# CITY OF ALBUQUERQUE

April 19, 2021

**Re: TI Glaz-Teck Industries  
6700 Bluewater Rd NW  
Traffic Circulation Layout  
Architect's Stamp 04-15-2021 (K10-D062)**

TRAFFIC CIRCULATION LAYOUT

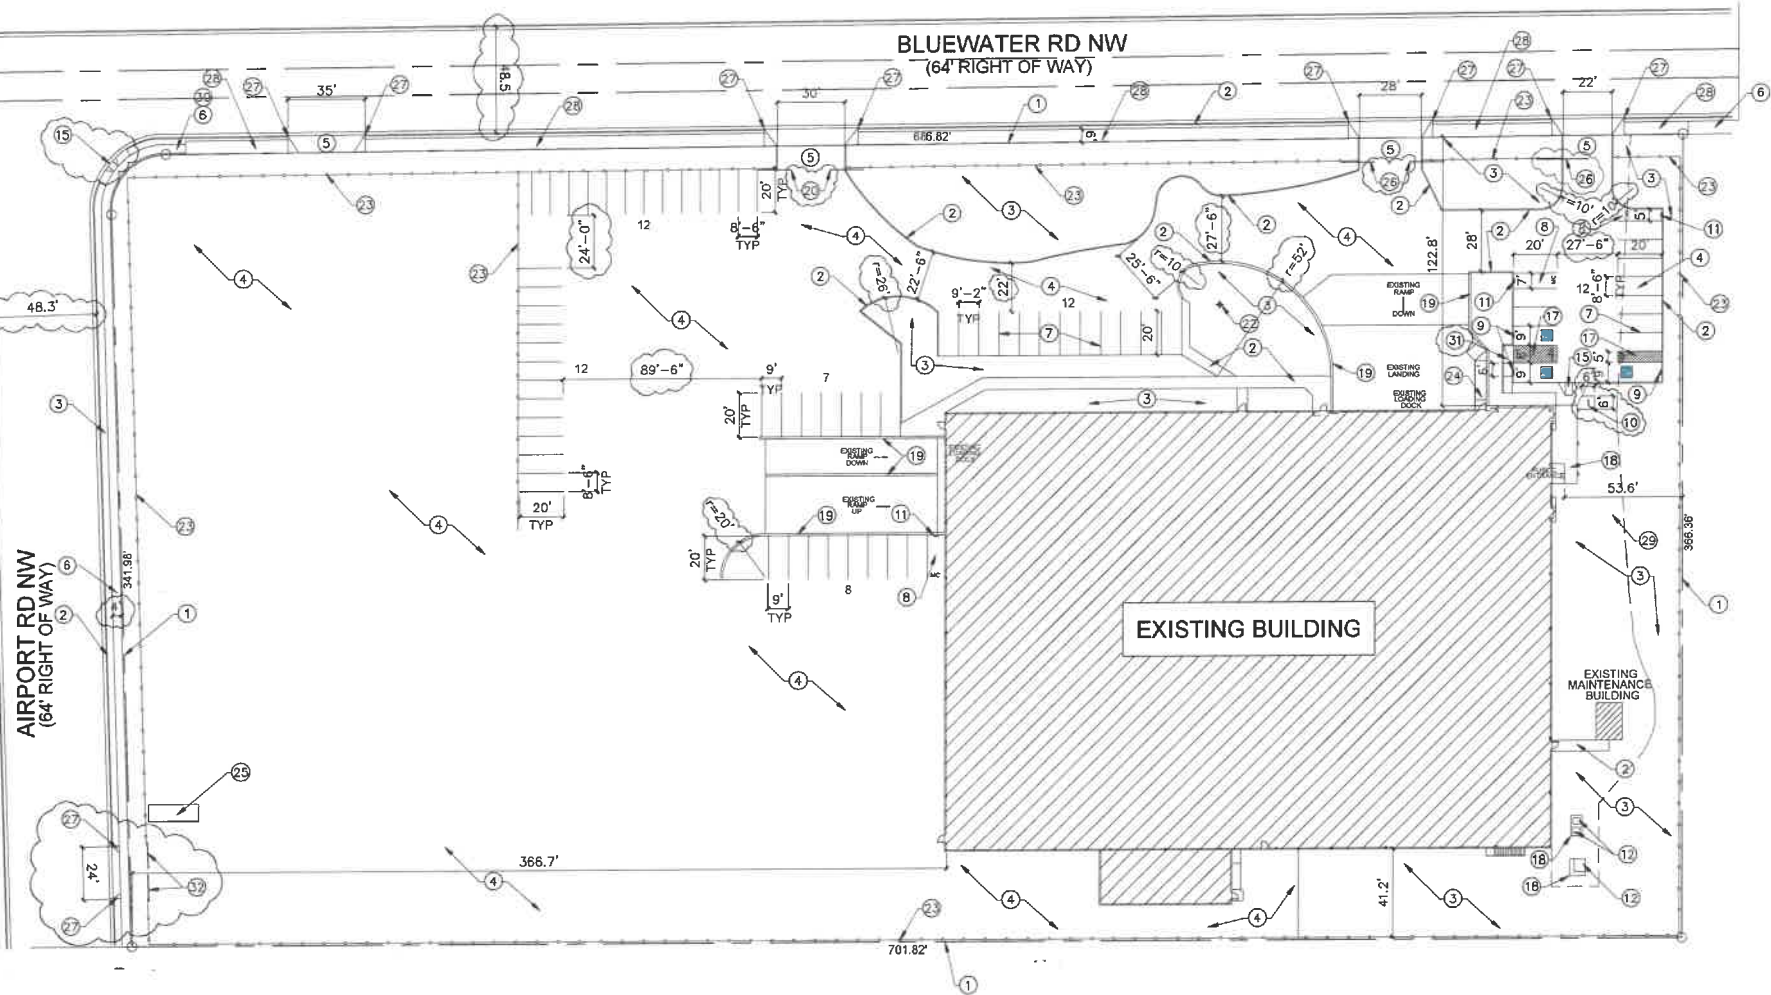
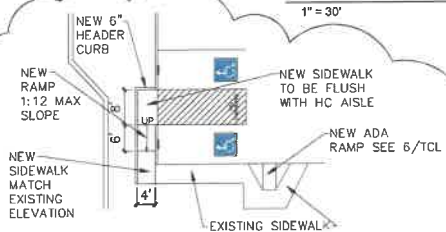
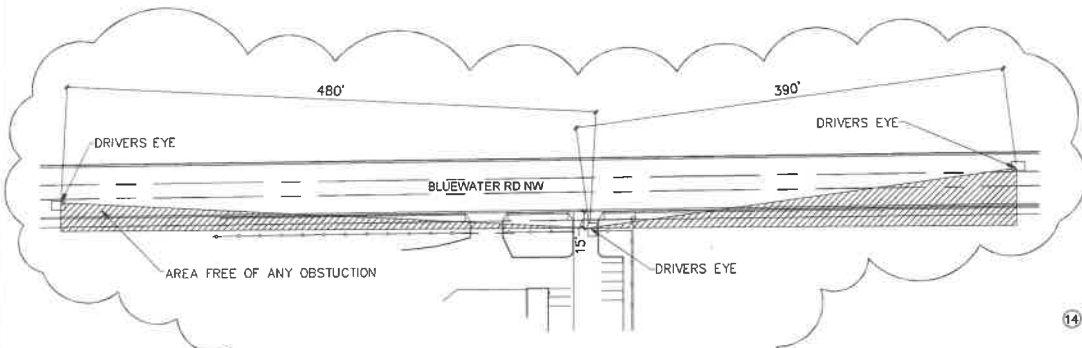
2. **(Comment Note 14):** Per DPM, a **6 ft. wide ADA accessible pedestrian pathway is required from the ADA parking stall access aisles to the building entrances.** Please clearly show this pathway and provide details. Provide a pathway from the 6ft wide ADA parking access aisle to the bldg. entrance: **Prior comment: you have not shown a pathway for the ADA parking stall across the drive aisle. This needs to be shown how ADA will traverse across the drive without any type of striping to delineate the 6ft pathway to the building entrance.**

3. **(Comment Note 15):** **ADA accessible pedestrian pathway should not be placed** behind parking space or **adjacent to a vehicular way.** Vehicle and pedestrian/wheel chair conflicts should be avoided as much as possible. You will need to find an alternative design for this type of pedestrian pathway outside of the drive aisle which conflicts with vehicle. This is a safety issue for **ADA pedestrian** which will need to be addressed by selecting an alternate route.

4. **Key Note 87:** Striping detail will need to be provided **(color of stripe and width).** **Correction Key Note 7, need to provide striping detail.**

1. **(Comment Note 2):** Identify the right of way width, medians, curb cuts, and street widths on Airport and Bluewater Road: This is the prior comment and since you will not respond to this comment please provide a stopping site distance exhibit (per DPM requirements) to insure there are no safety concerns on the Bluewater Road driveway on both directions.

5. **(Comment 21 & 22):** Please provide a sight distance exhibit. The exhibit you provided is for the an intersection corner. You will need to provide an exhibit for the driveway (see DPM).
